Final Plat of

ABERT RANCH SUBDIVISION

In the NE Quarter of Section 23 & in the NW Quarter of Section 24, T 11 S, R 66 W, of the 6th P.M., El Paso County, Colorado.

PLAT V_2 redlines.pdf Markup Summary

Final Plat of ABERT RANCH SUBDIVISION

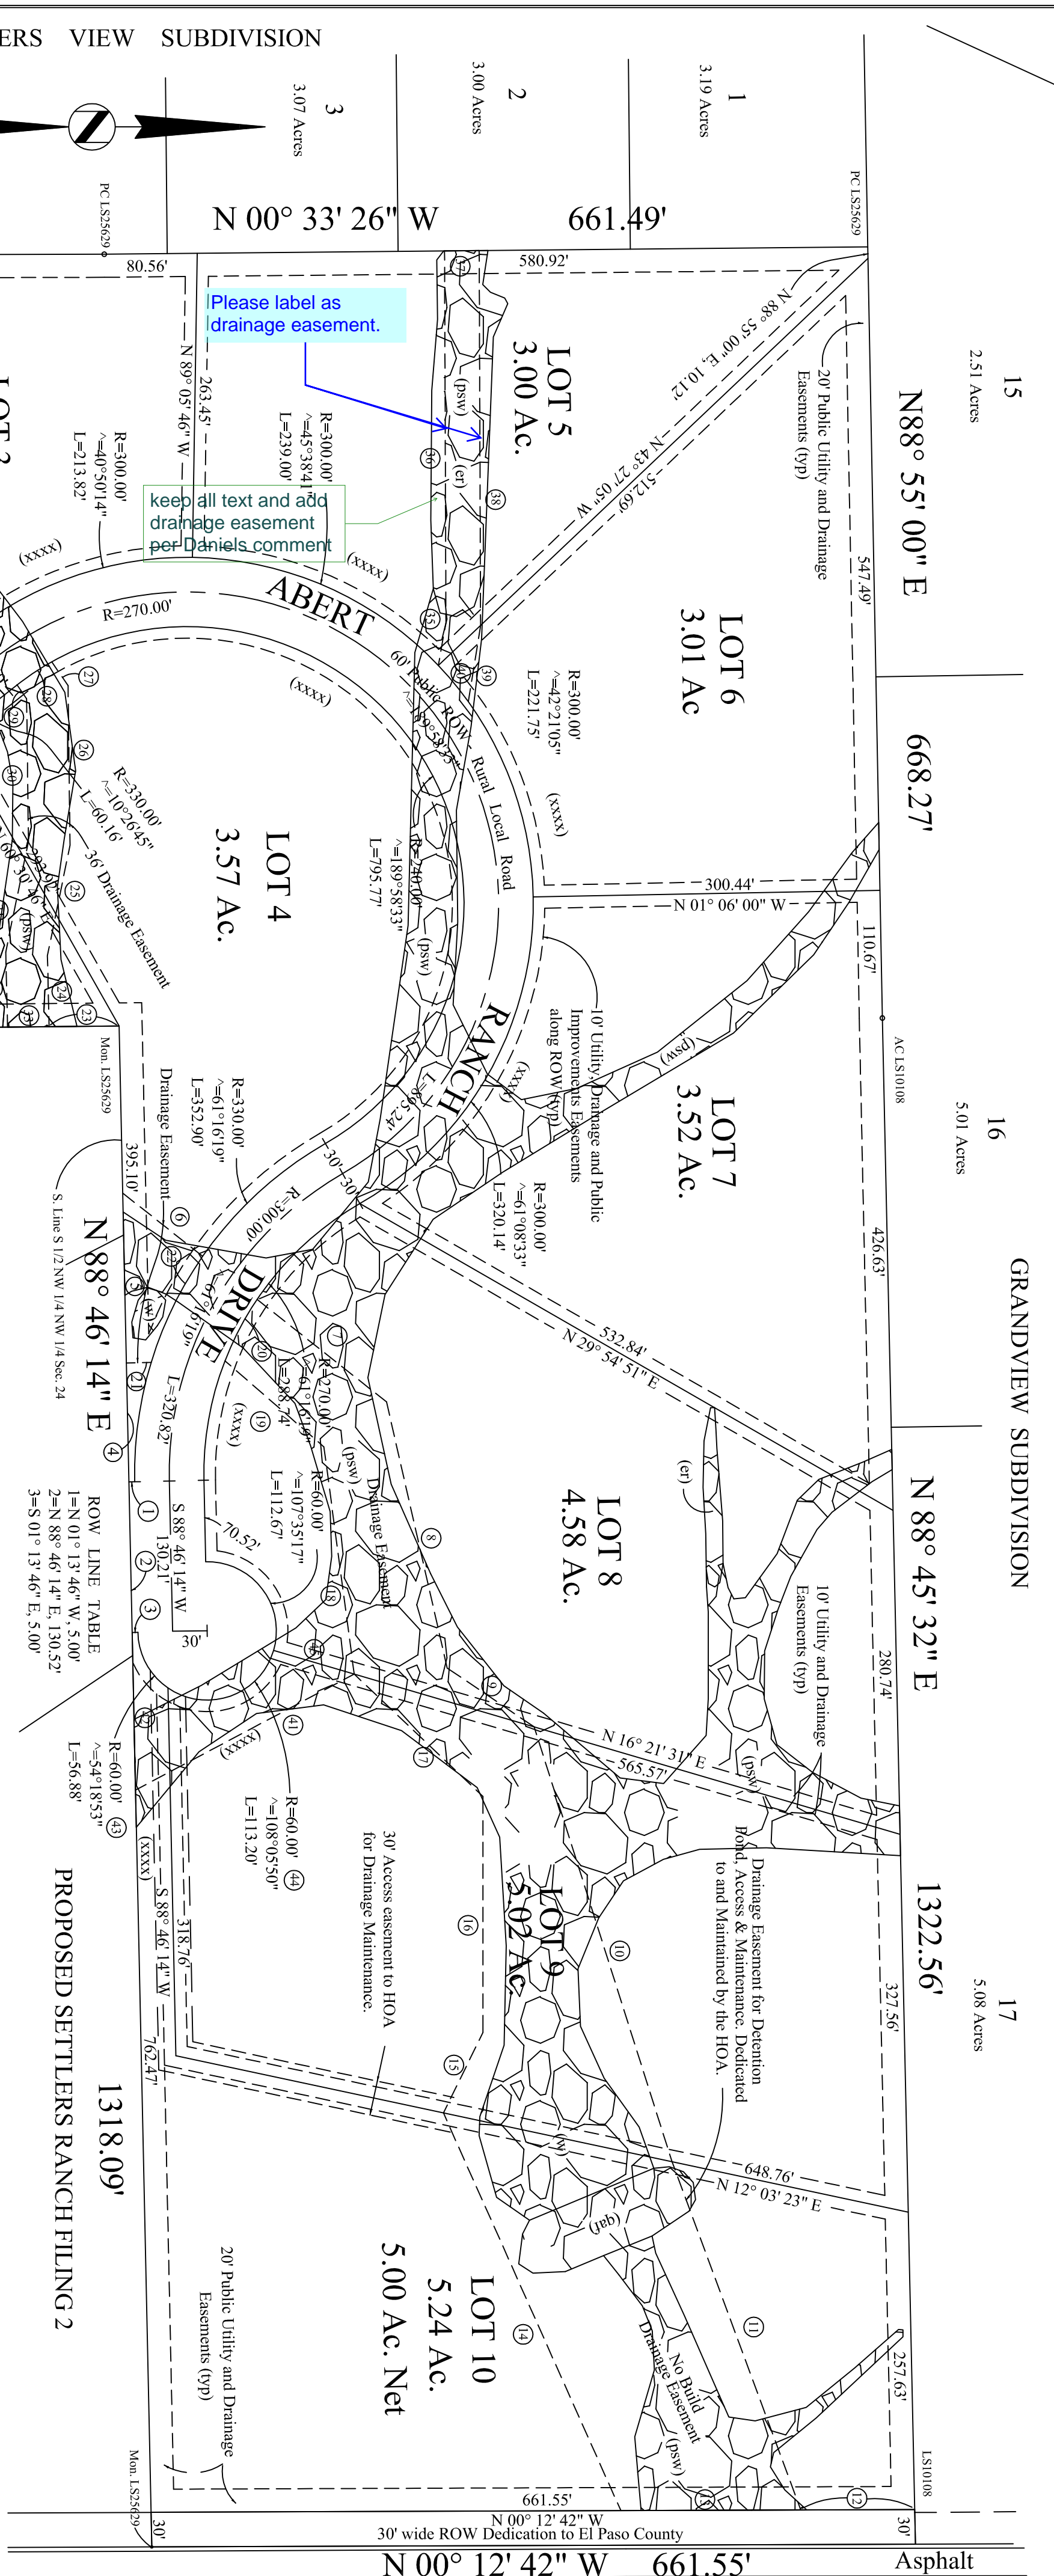
Review 1 comment: Provide easement for channel. See comment on drainage report.

Please remove contour lines from the Plat drawing.

Review 2: Unresolved. Please provide an easement for this channel. A comment on the drainage report has been provided to identify the width of the easement. N 88° 55' 00" E

Lot 1 and Lot 2 Please revise.

Provide distance and bearing of sight distance easement.

Missing the rest of the note to release - you need a second sheet for the plat.

Please remove contour lines from the Plat drawing.

Lot 1 and Lot 2. Please revise.

Review 1 comment: Provide easement for channel.
See comment on drainage report.

Review 2: Unresolved. Please provide an easement for this channel. A comment on the drainage report has been provided to identify the width of the easement.

Identify the min. width of the drainage easements.
Coordinate with the engineer.
